TAMWORTH REGIONAL COUNCIL SUBMISSION - MODIFICATION OF STATE SIGNIFICANT DEVELOPMENT- BAIADA SSD-9394 MODIFICATION 6 CHANGES TO WASTEWATER TREATMENT PLANT (SSD-9394-MOD-6)

I refer to your correspondence received 23 April 2026 regarding the public exhibition of Modification of State Significant Development, being the Baiada SSD-9394 Modification 6 Changes to Wastewater Treatment Plant (SSD-9394-MOD-6).

Figure 4: Proposed WWT Layout - Stage 1

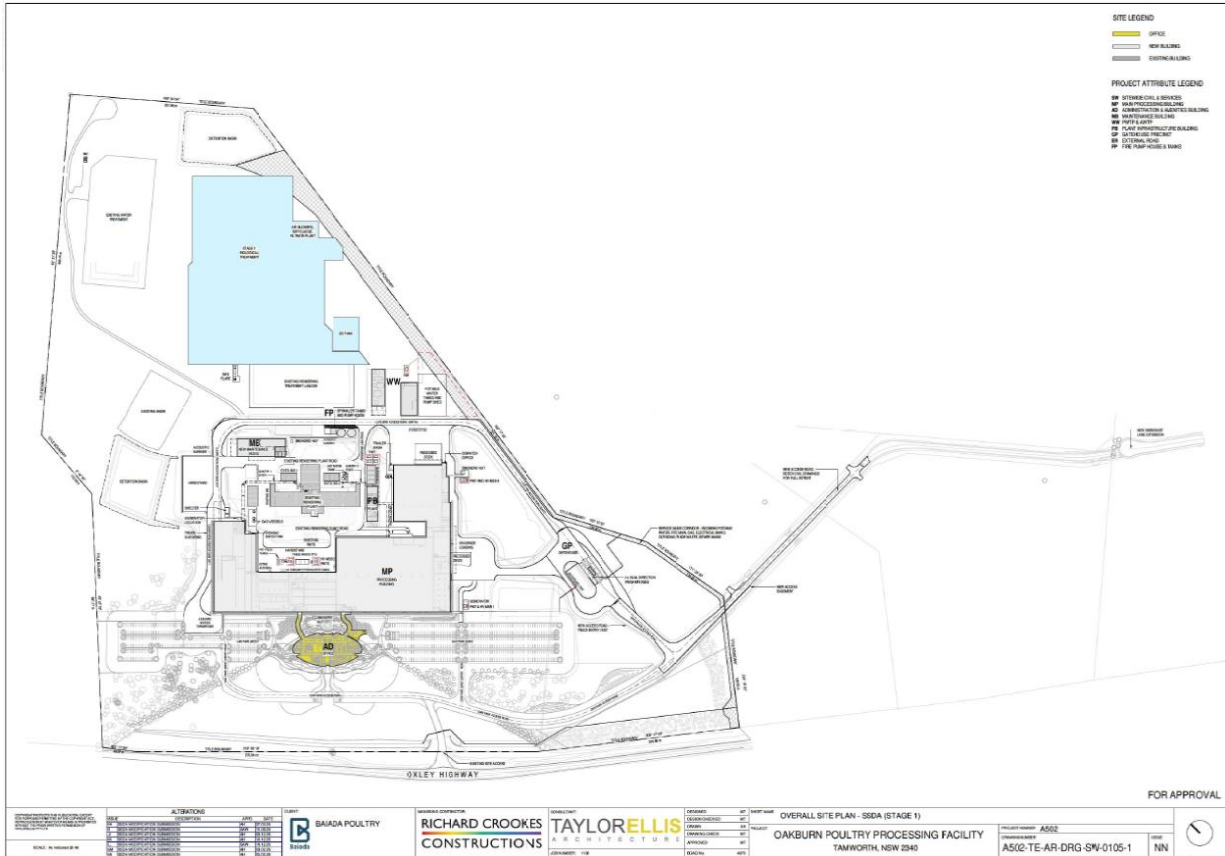
The submitted Stormwater Catchment details and management strategy appear to relate only to Stage 1 of the proposed development.

- Detailed site plans for each stage of the proposed development;
- A comprehensive stormwater catchment plan and stormwater management strategy for each stage of development, including relevant flow calculations;
- Detailed information regarding the proposed conversion of Detention Basins A and B into brine holding ponds, including any specialised design and construction requirements associated with these works.

Figure 6: Proposed WWTP Layout – Stage 3 (Concept Design)

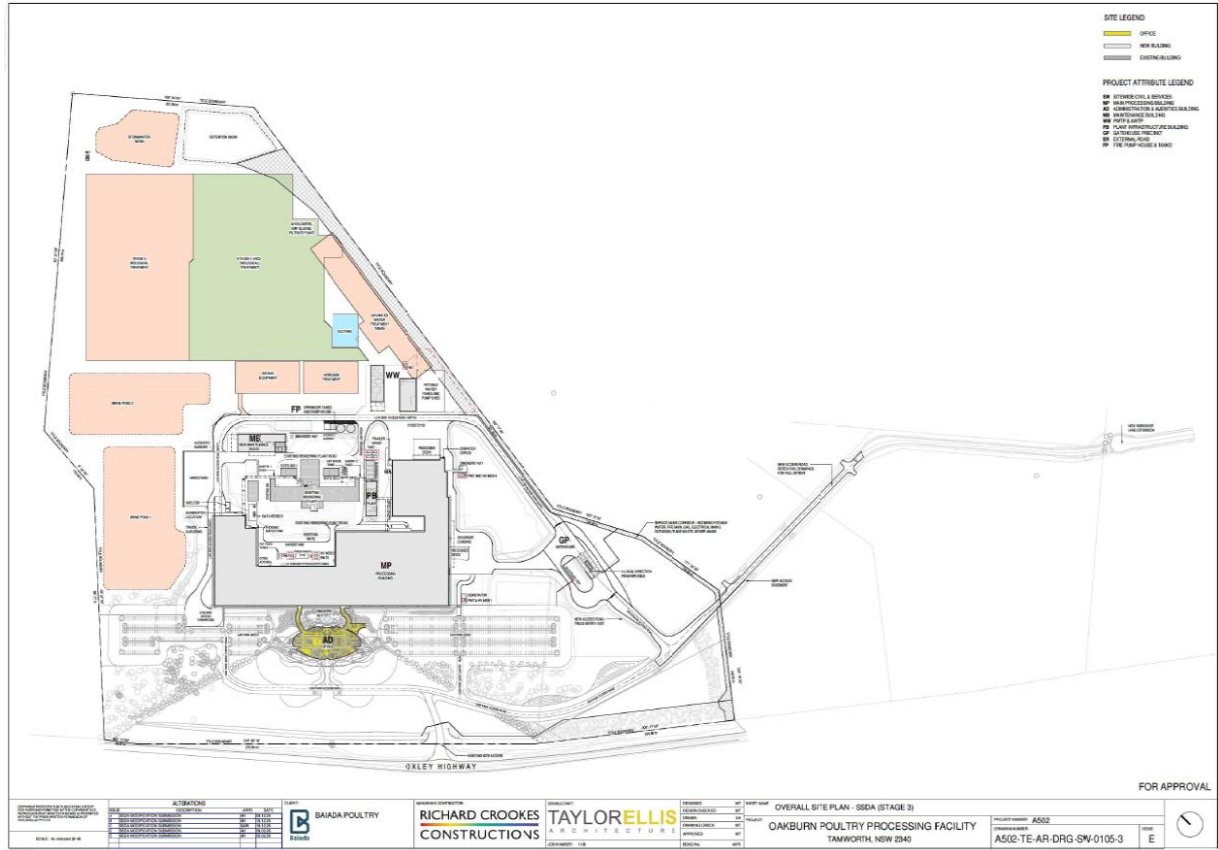
In particular, the Stage 3 plans appear to indicate the conversion of Detention Basins A and B into brine holding ponds. However, this proposed change has not been addressed or detailed within the submitted Stormwater Strategy documentation.
